BATTERY BOX HOLBEACH BOX ENERGY STORAGE SYSTEM

VARIATION OF CONDITION

Name and Address of Applicant:Mr Thomas Fox-Davies
AMP Clean Energy 1, Dover Street London W1S 4LD
Address: Land To The East Of Boston Road, Holbeach PE12 7EE
Date of application: 24 th June 2024
Application Number: H09-0597-24
Local Planning Authority: South Holland DC
Description of the Proposal: Construction and operation of a micro energy storage facility
Date of decision: 19 th September 2024

This submission seeks to make a non-material amendment to condition 2 and 3.

REV.	DATE	DESCRIPTION
<b>BATTERY BOX</b>		
AMP CLEAN ENERGY 1 DOVER STREET LONDON W1S 4LD		
amp CLEAN ENERGY		
200kW / 800kWh MICRO ENERGY STORAGE UNIT		
BATTERY BOX BATTERY EQUIPMENT		
PLANS AND ELEVATIONS		
PLAN 4		
REV		
Scale	1:50	Date
		SEPT 2024

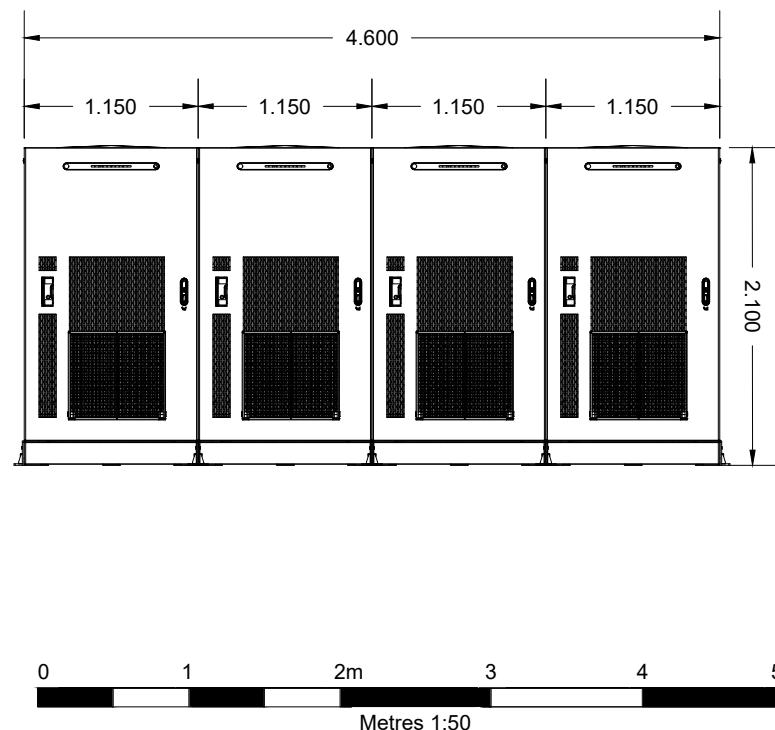
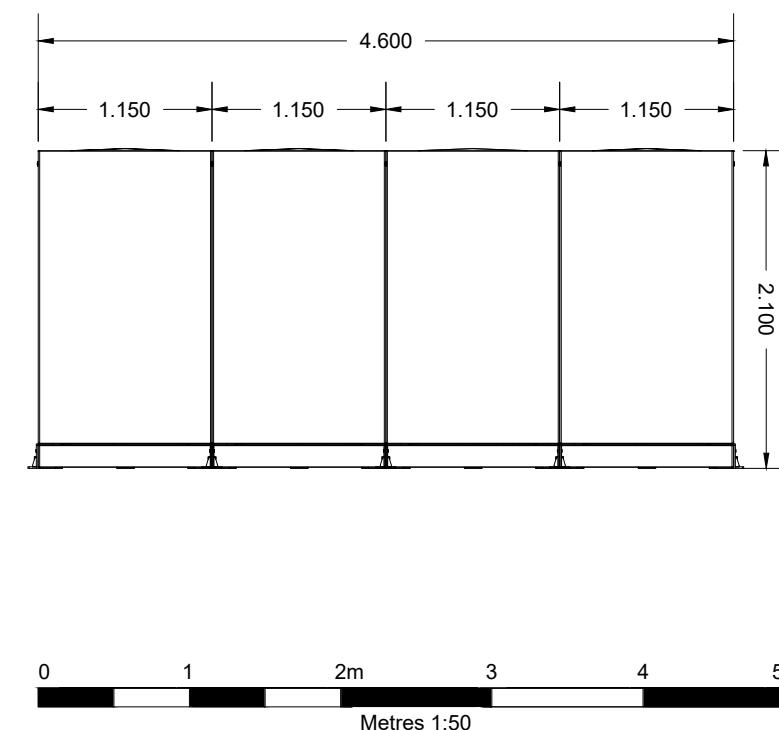
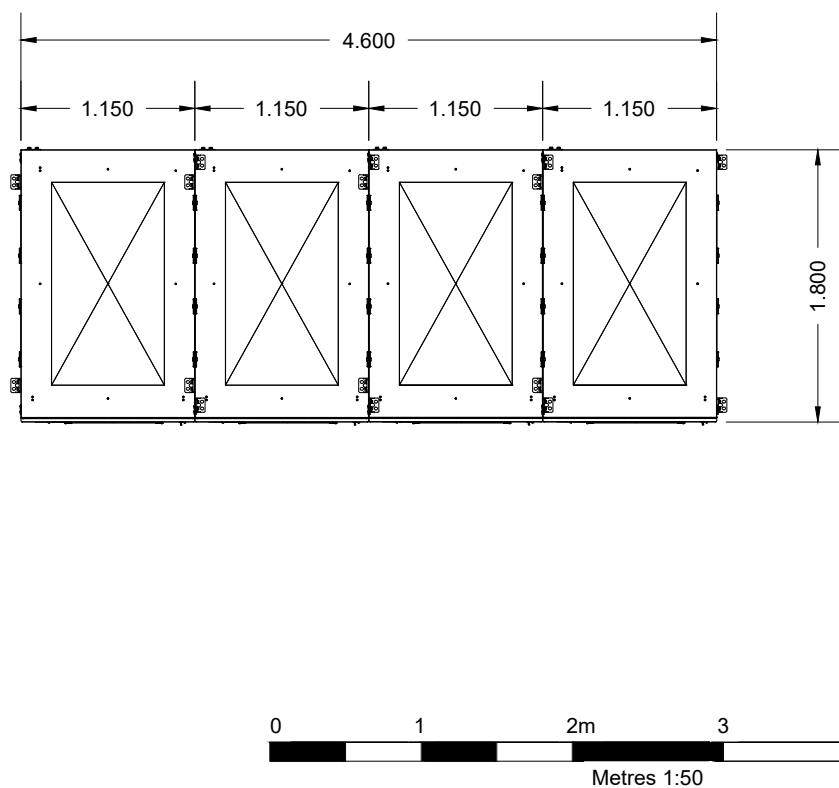
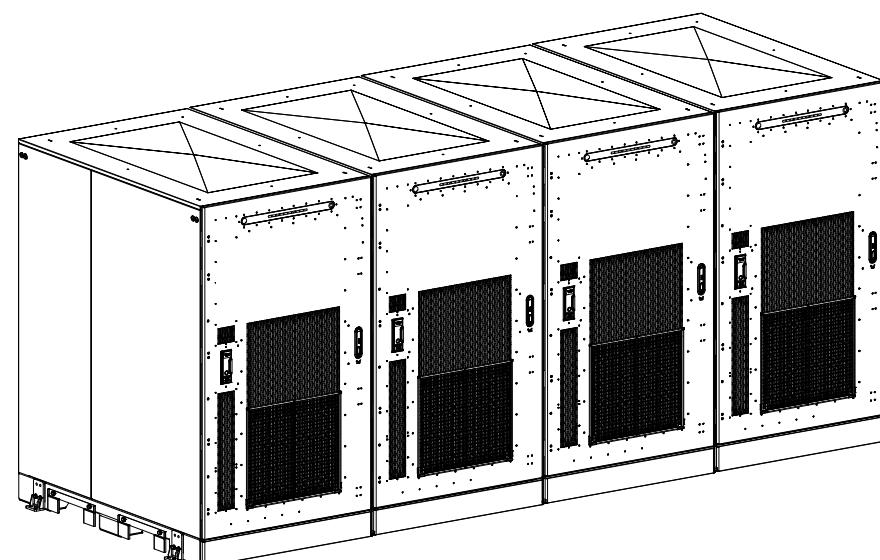
Consented Scheme	Proposed Amendments
Total footprint (LxW) Sqm	$6.00m * 4.00m = 24.00m^2$	$6.35 * 3.90m = 24.77m^2$
Battery Unit Height	2.78m	2.41m
Fence Type	Palisade - 20 m Perimeter	Paladin - 9.99 m Perimeter
Battery Units/PCS/Electrical Cabinet	2 Battery units 1PCS 1 Electrical Cabinet	4 Battery Units (PCS Included) 1 Electrical Cabinet

Plan Submitted with original application	New Plan
02 - Site Layout Plan	02 - Site Layout Plan NMA Oct 2024
04 Battery Equipment – Plans and Elevations	04 Battery Equipment – Plans and Elevations NMA Oct 2024
05 Electrical Cabinet – Plans and Elevations	05 Electrical Cabinet – Plans and Elevations NMA Oct 2024
